Engineers Comments Regarding Surface Water Drainage

Application Reference:	P/59/25/DOC	Reviewer Reference:	ADC/EXT2/D2134/74
Planning Officer:	Amber Willard	Date of Review:	14.01.2026
Site Name:	Sefter Farm Pagham Road Pagham PO21 3PX		
Application Description:	Approval of details reserved by condition imposed under reference P/117/21/PL relating to condition number 7 - surface water drainage scheme.		
Assessment Number:	1 of 2

DRAWN A Davies	DATE Apr 2025	PROJECT NO. 24019
ENGINEER S Doughty	CHECKED SRM	DWG No. 401
SCALE 1:250 @ A1, 1:500 @ A3		REV. -

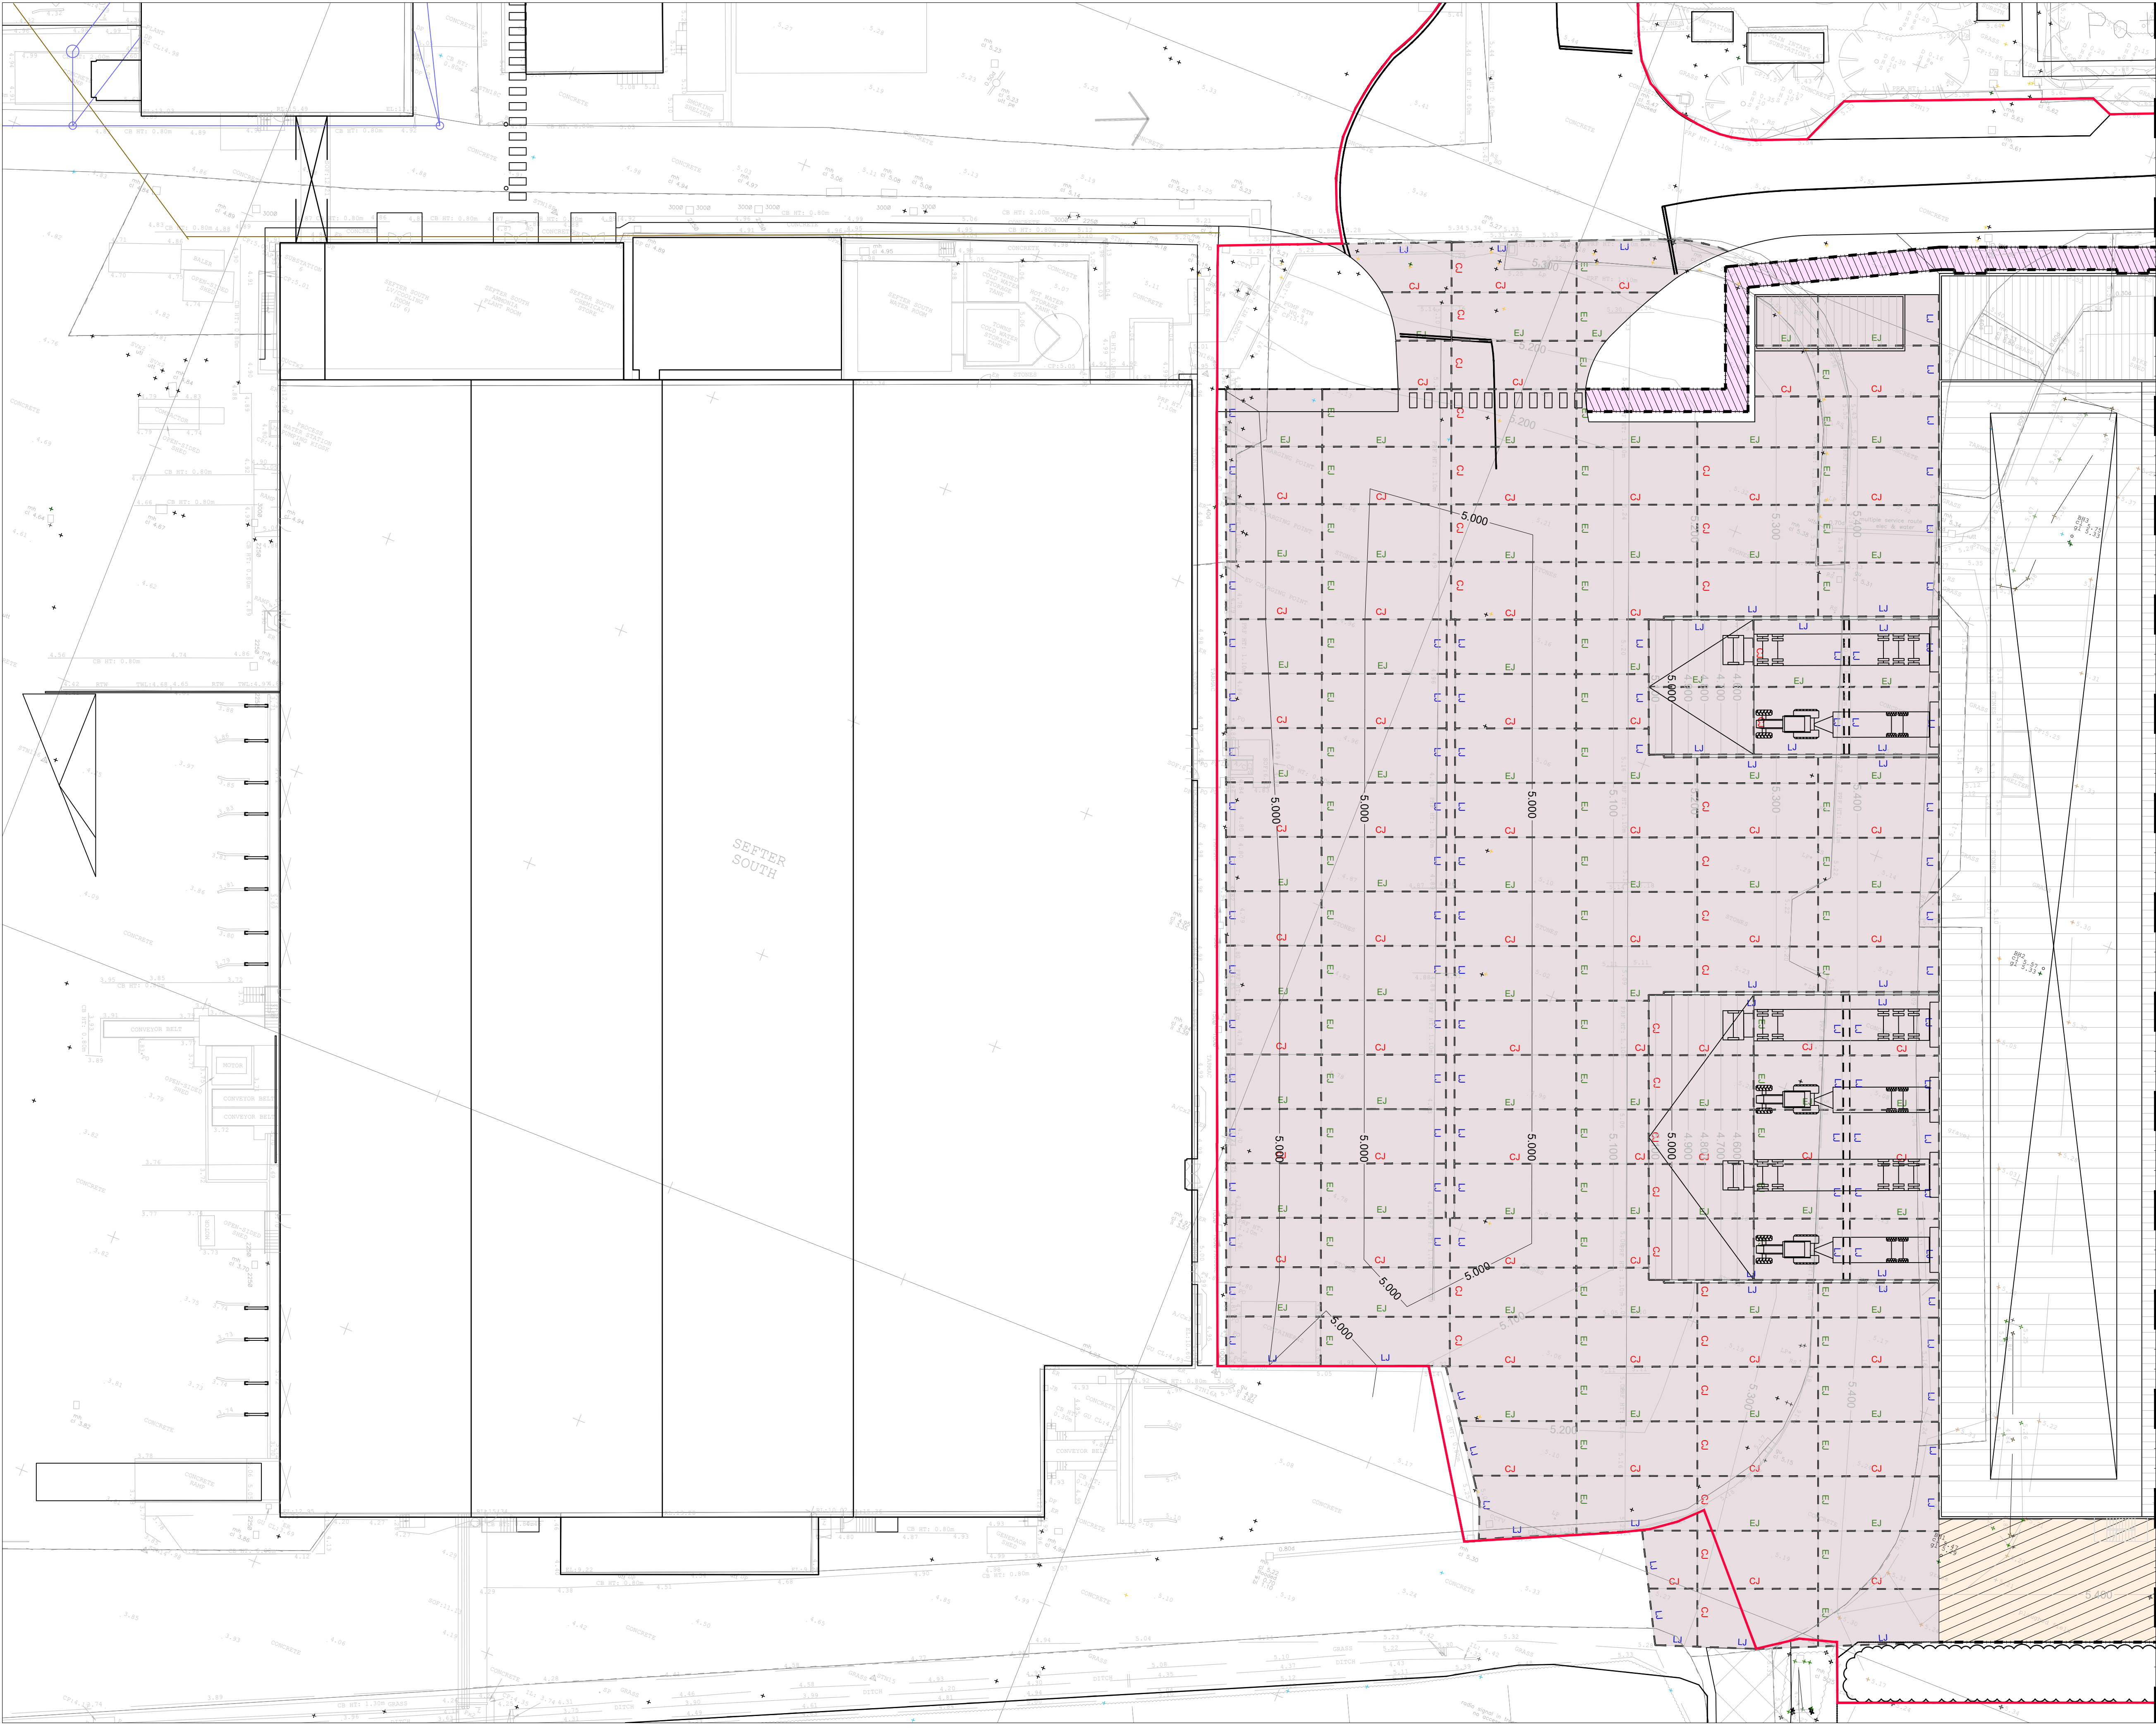
11.	Permeable pavement construction details must be updated to qualify kerbs/edgings Designer Response 26/08/2025	Please see response to comment 9 above. Comment outstanding.	We have included further details of the EF edging at the edge of the permeable pavement construction.	Noted. Comment closed.

As previously noted: There are edgings shown where relevant on the surface finishes detailed design drawings submitted with the Discharge of Conditions application. Please see Surface Finishes Drawings 24019-401 and 24019-402		See Drawing 501B.
